Your ref:
Our ref: 22/00949/F
Please ask for: Miss Sandra Homcenko
Direct dial: 01553 616824
E-mail: borough.planning@west-norfolk.gov.uk

Details: **Retrospective planning application for 3no. outbuildings sited to rear of property. Change of use of agricultural land to domestic garden at 2A The Drove Barroway Drove Norfolk PE38 0AJ**

DRAWING TITLE
 Block Plans As Existing and As Proposed

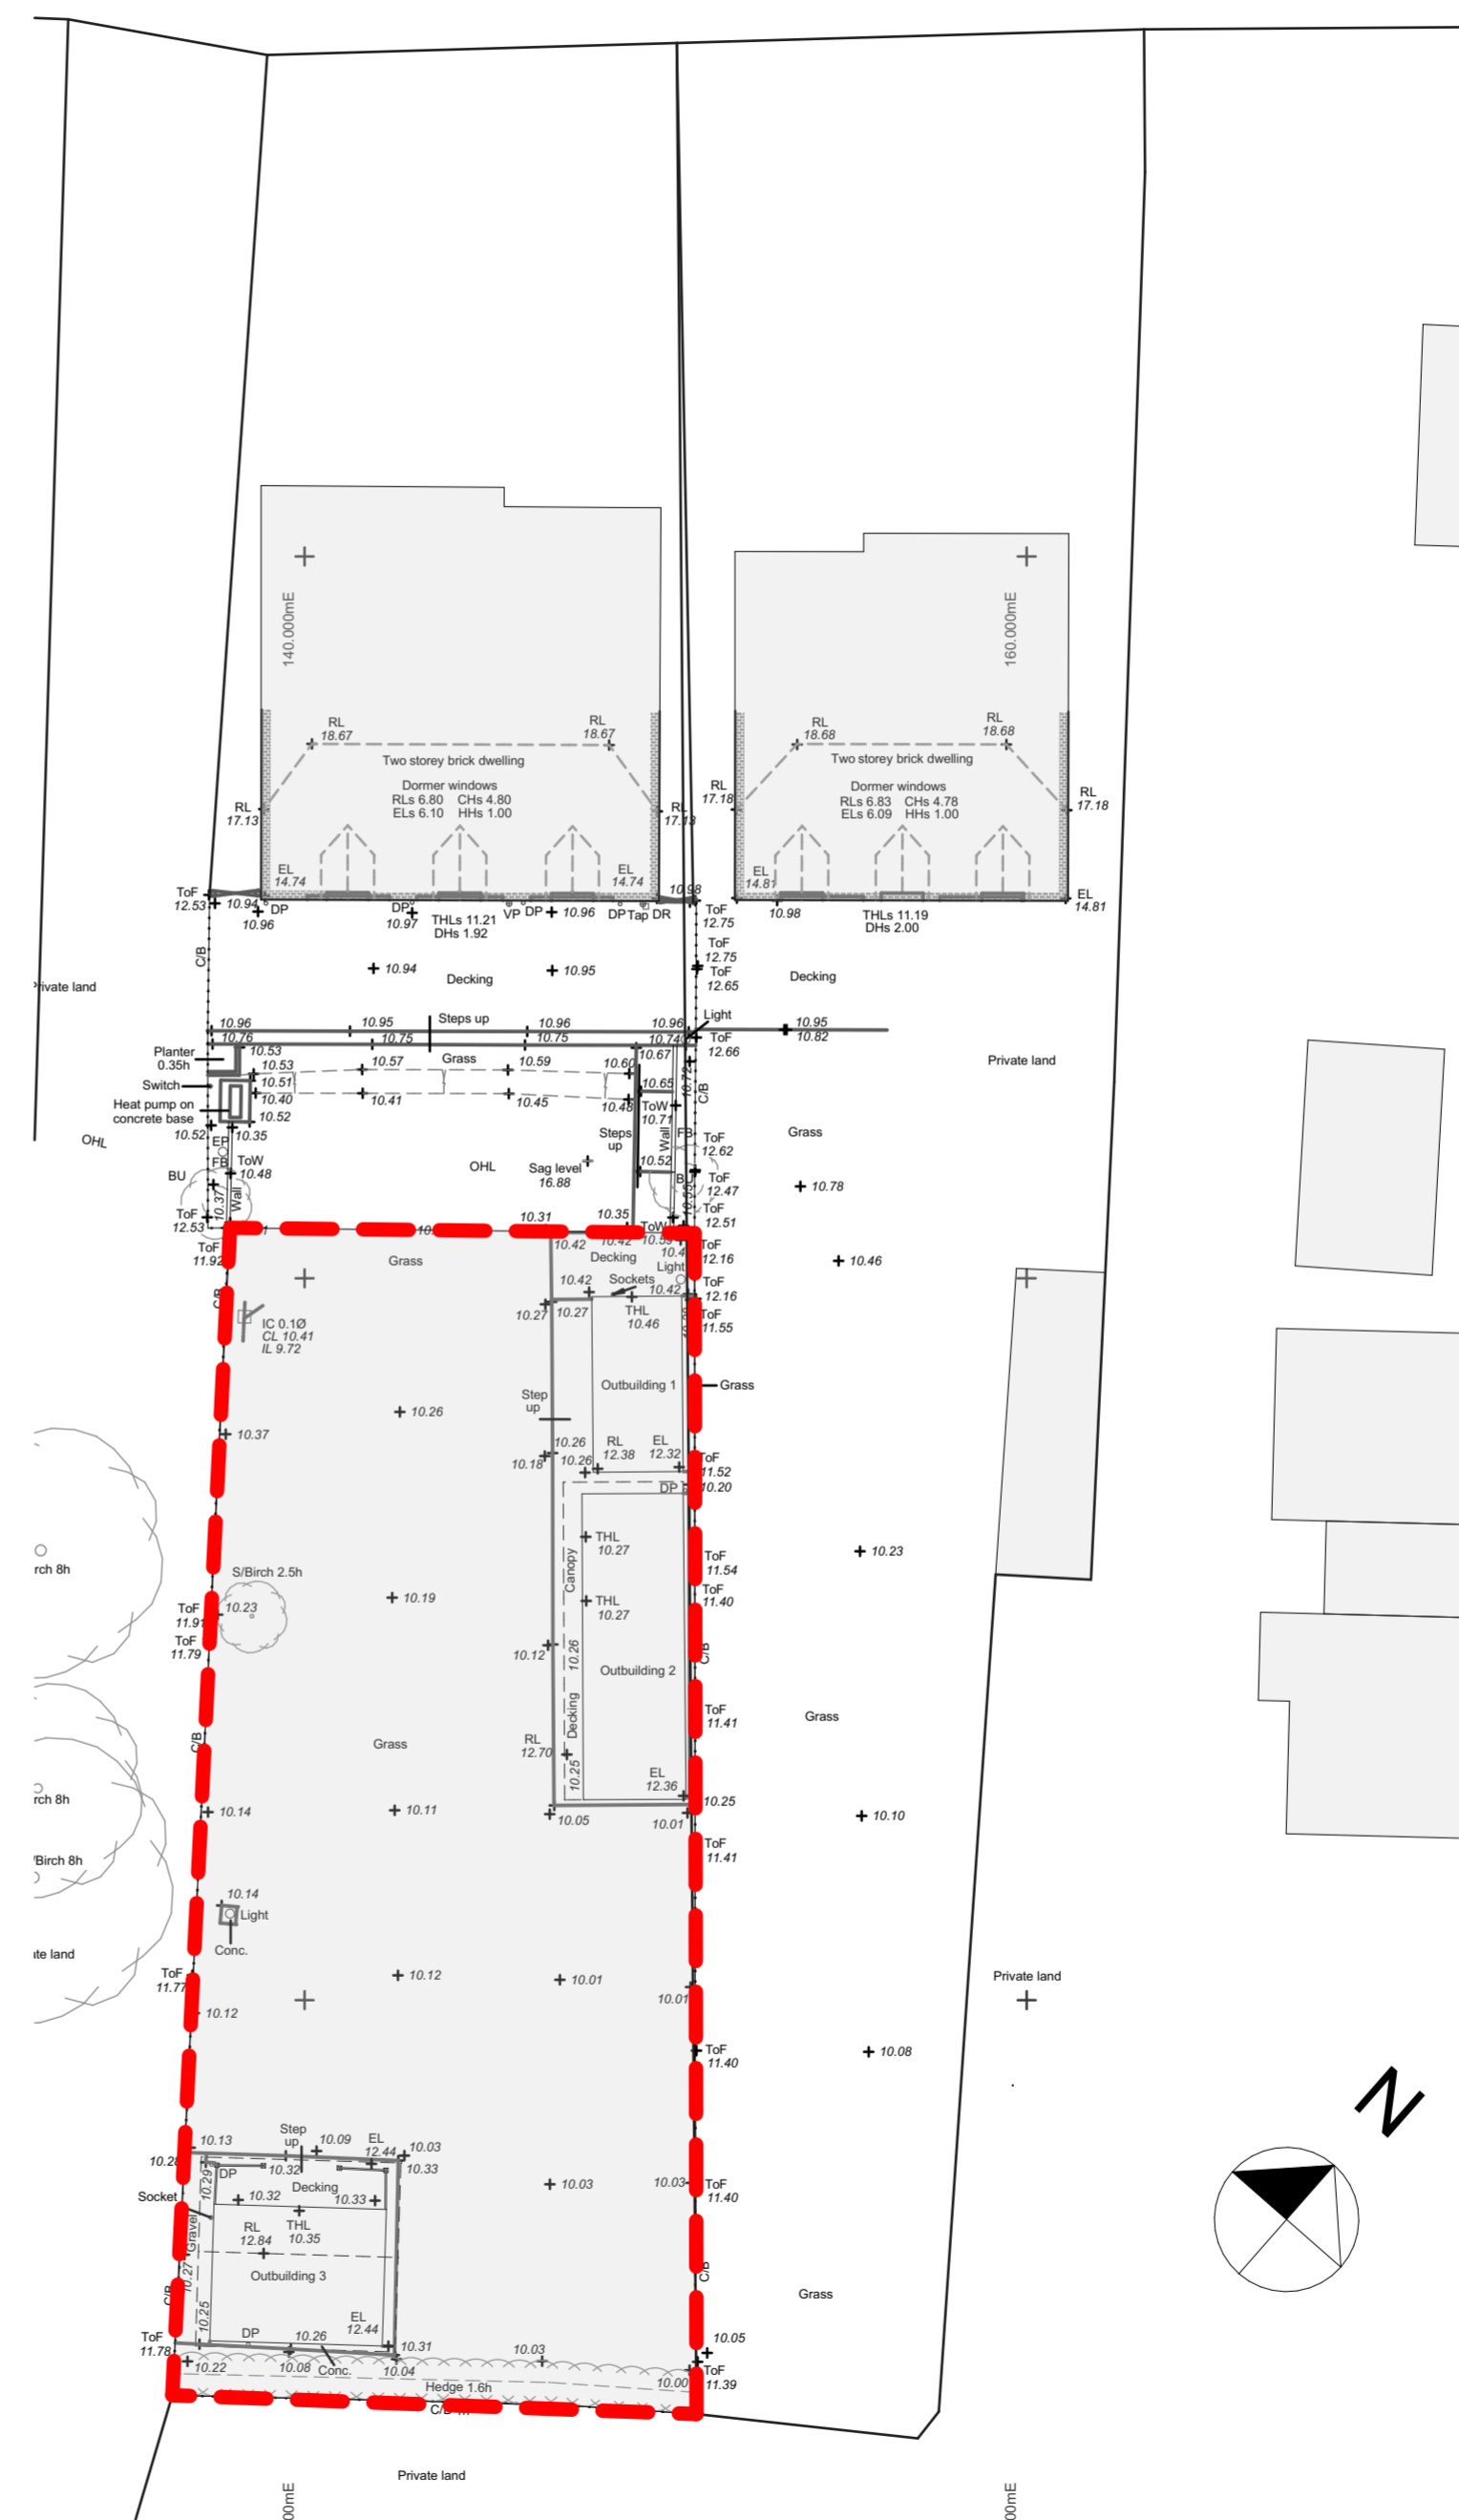
3. Please provide Existing and Proposed Block plans to scale of either 1:200 or 1:500
4. Please amend Location plan, the site applicable to the change of use should be edged in red and any other adjoining land in applicants ownership should be edged in blue.
